**KIRKLEES METROPOLITAN COUNCIL
INVESTMENT & REGENERATION SERVICE**

DELEGATED DECISION TO DETERMINE PLANNING APPLICATIONS

Reference No:	2024/62/92477/E
Site Address:	1, Cambridge Street, Batley, WF17 5JH
Description:	Change of use and alterations to lower ground floor storage to extend nursery facilities (class E(f)) (within a Conservation Area)
Recommending Officer:	Edward Cheseldine

Officer Report

PROJECT NAME 01 Cambridge Street, WF17 5JH			
DRAWING TITLE Proposed Floor Plan & Elevation		DRAWN BY/ CHECKED BY MR/FY	
PHASE Concept	SCALE 1:50 @ A3	SHEET NO. AR-03	PROJ.NO. C24003

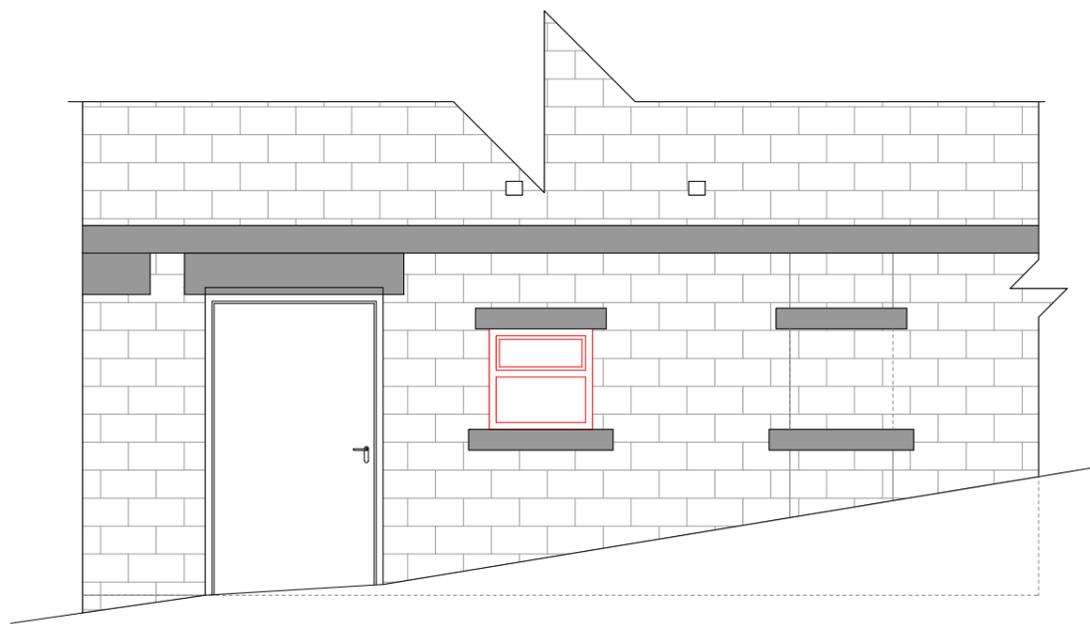
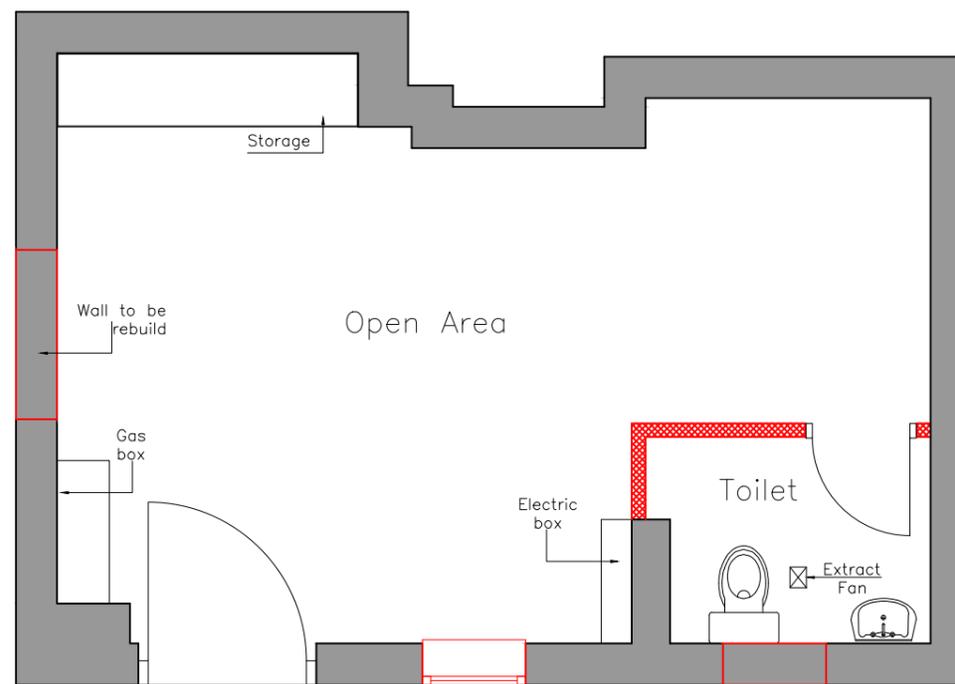
An amended window design was requested, so that the appearance of the window was in harmony with the ornate window details situated above on the first-floor level above. The placement of the vent was also requested.

The window will be placed below the existing window. The window above features a 1:1 central column which the proposed window will replicate. It will have a natural stone lintel and cill which will be conditioned in order to preserve the appearance of the conservation area and building.

The placement and appearance of the window is sympathetic to the historic environment of the conservation area. Due to the alterations to the design of the window, it will appear symmetrical to the existing fenestration placement. Notwithstanding the above, the application has not been accompanied by window elevations plans. It will be conditioned that the glazing type, materials, profiles, colour, opening configuration and mechanisms, and depth within the reveals are identified on plans and approved in writing by the local planning authority in order to ensure a satisfactory appearance. They should in all respect match the central column of the window above, with an internal section sufficient to accommodate slim double glazing. External extractor vent details shall also be submitted and approved in writing by the local planning authority in order to comply with LP24 & LP35.

3. Notwithstanding the submitted plans and information, details of all proposed windows (1:20 elevations and 1:5 joinery details) shall be submitted to and approved in writing by the Local Planning Authority before their installation commences. Submitted information shall include glazing type, materials, profiles, colour, opening configuration and mechanisms, and depth within the reveals. Double glazed units shall be slim in section (4:8:4) with black spacers. Friction hinges, egress hinges and visible trickle vents shall not be permitted. The development shall be completed in accordance with the approved details and thereafter retained.

4. Notwithstanding the details provided, all windows shall match the existing joinery details in terms of material, profiles, detailing, dimensions and colour, albeit with timber beading in place of putty beads and an increase in the internal section sufficient to accommodate slim double glazing. All slim double-glazed units shall have 4mm glass with an 8mm gap with black spacer bars.

5. No works to install external extractor vents shall take place until full details have been submitted to and approved in writing by the Local Planning Authority. The works shall then be carried out in complete accordance with the approved details and shall be retained thereafter.

6. All new stonework including, heads, sills, and window surrounds, shall be constructed of natural stone.
